**Ann Machado - Re: Fwd: Penthouse equipment**

**From:** Liv Chase <livchase@yahoo.com>  
**To:** Ann Machado <AMACHADO@portlandmaine.gov>  
**Date:** 3/16/2015 5:53 PM  
**Subject:** Re: Fwd: Penthouse equipment

Here are the tech specs for the mechanical equipment that will occupy the penthouse at 48 Hancock St.

10 FIFTH FLOOR PLAN
All/All 0 8'-0" SCALE: 1/8" = 1'-0"

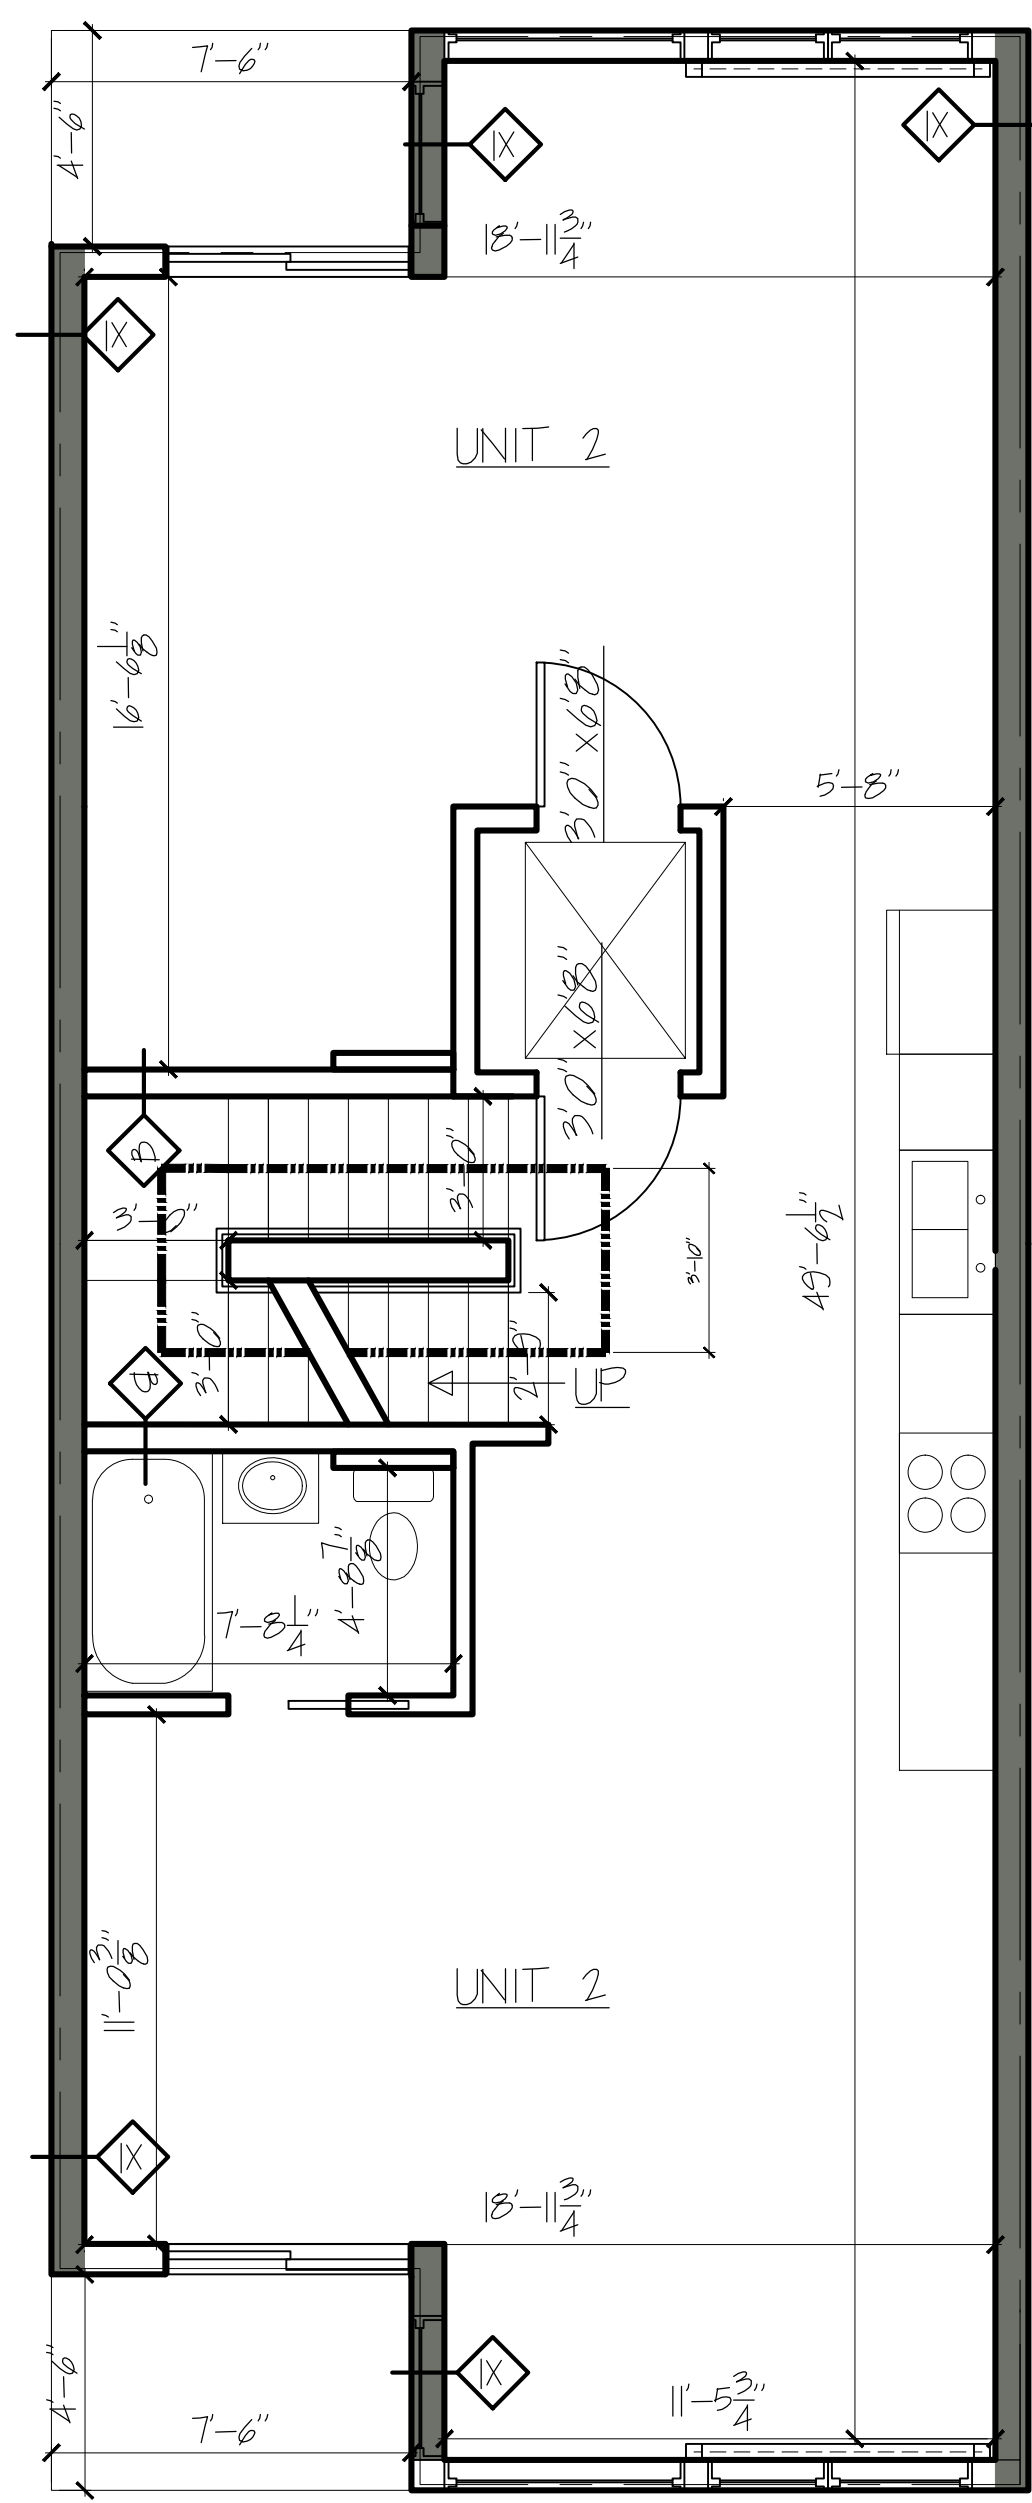
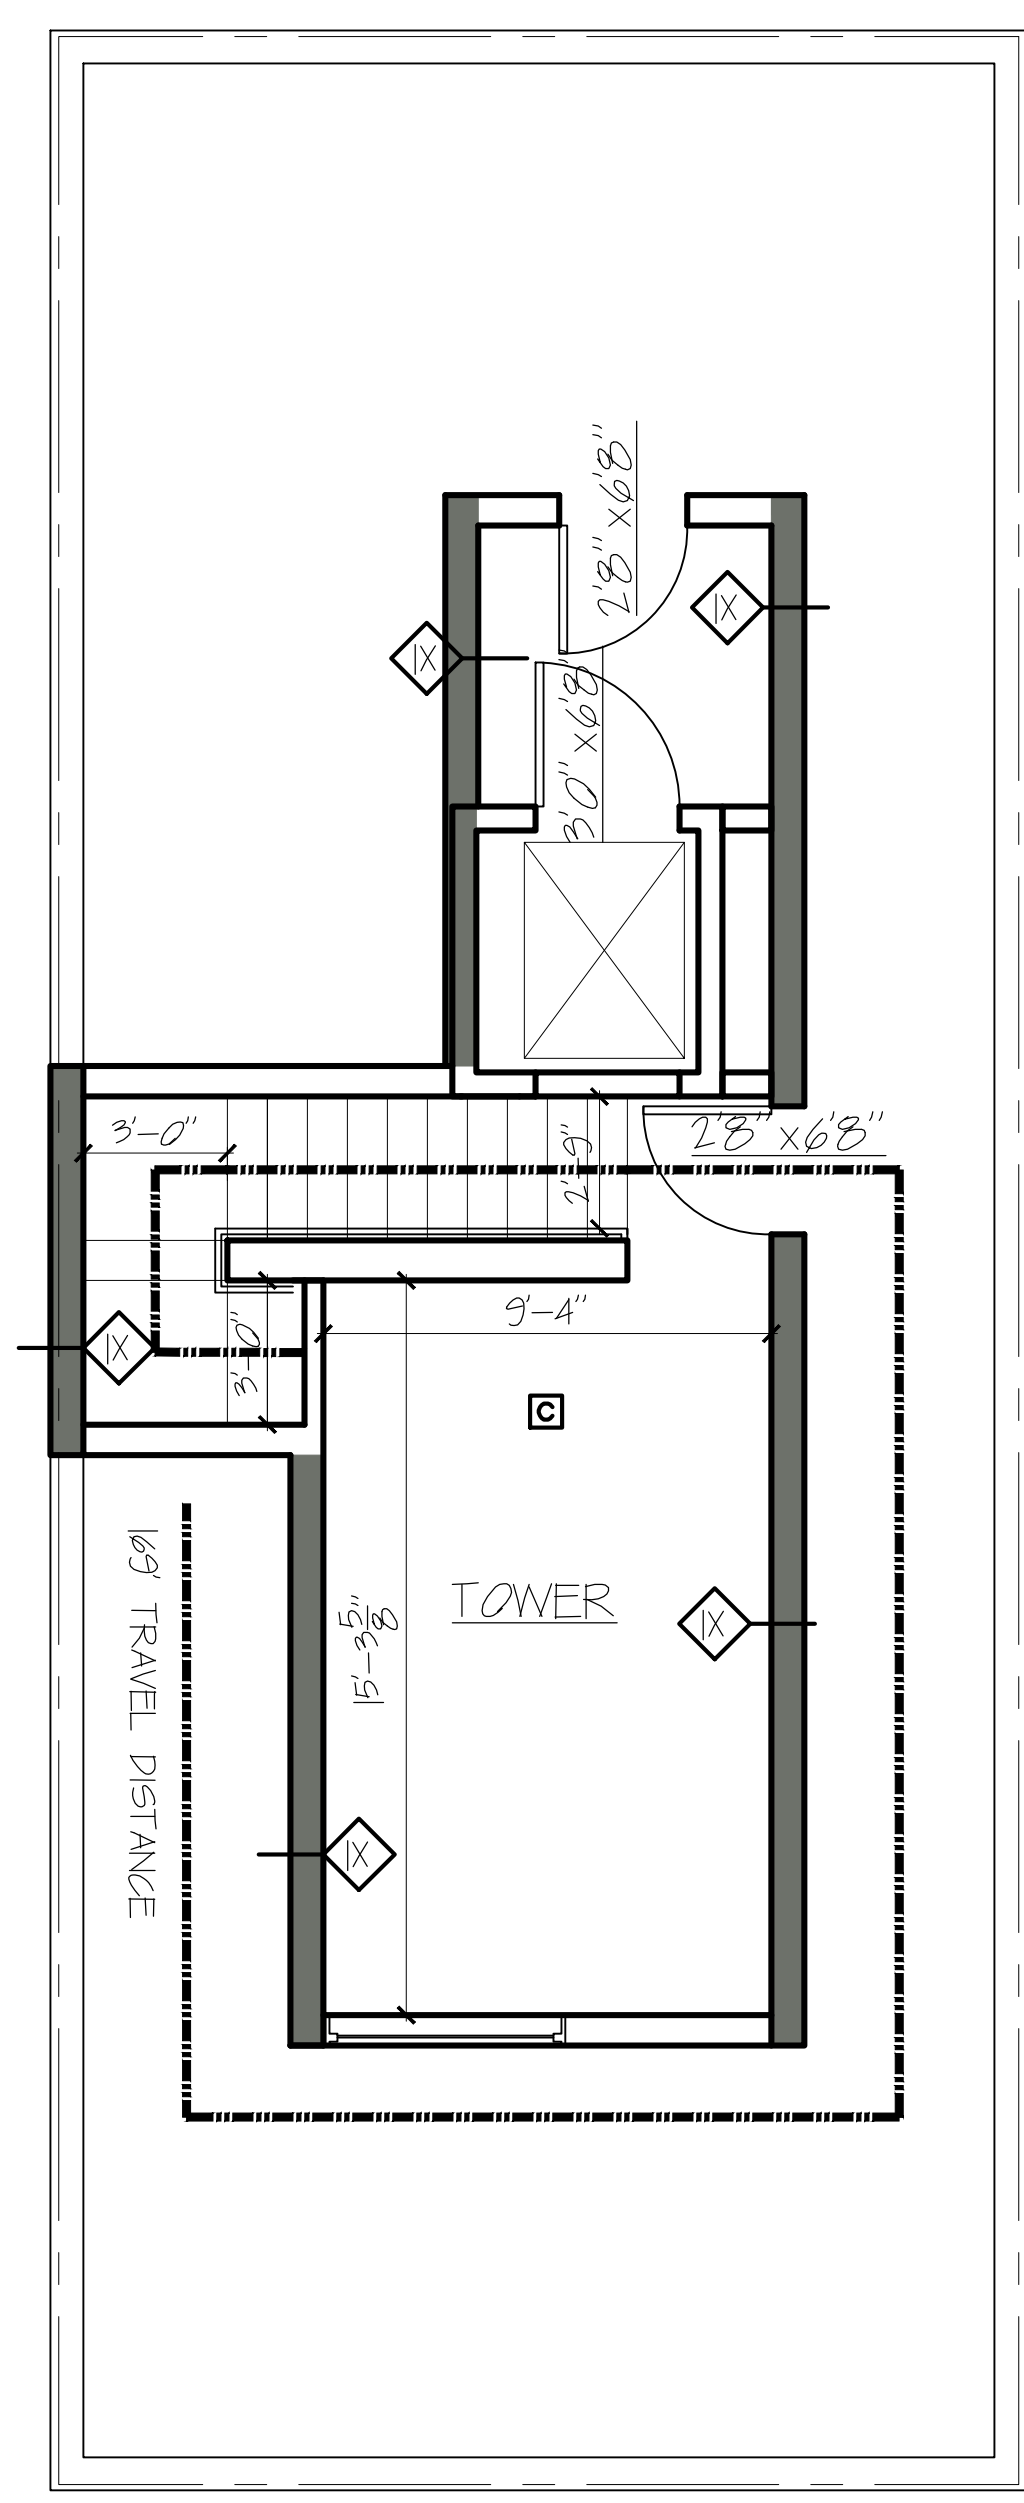
One final question. Is there a deck on the roof for the tenants since the elevator goes up there?

Is the "auxiliary space for the rooftop" where the heat pump is located going to be separated by a wall and door from the stair access area? Or is the stair access only for access to the mechanicals?

Is there a deck on the roof?

Plan A1.1 gives the dimensions of the fifth floor auxiliary space as 9'4" xs 15'3 5/8". I don't know anything about heat pumps but it seems like a big area for housing a heat pump. It would be helpful to have a diagram to scale showing the heating unit within the space.

Hi Ann,  
I didn't decide to put a deck yet, but the entire perimeter of the roof has either a parapet or railing that is 42" high and the roof will be made out of materials that allow for people to walk on the roof.  
Hope this helps.  
Thanks,  
Liv

Hi Ann,  
There was no plan to have a wall between the stair and the mechanical room. The stair was to access the mechanical room.  
The elevator was intended to be access for the roof.  
-Liv

Thanks for the reply. As noted in the documentation provided, the heat pump water heater requires a minimum of 1000 cubic feet of space due to the intake of air. The unit itself is only 27" in diameter and 60" tall. If you need Evan to draw this in the space, I think he could most likely draw a circle.
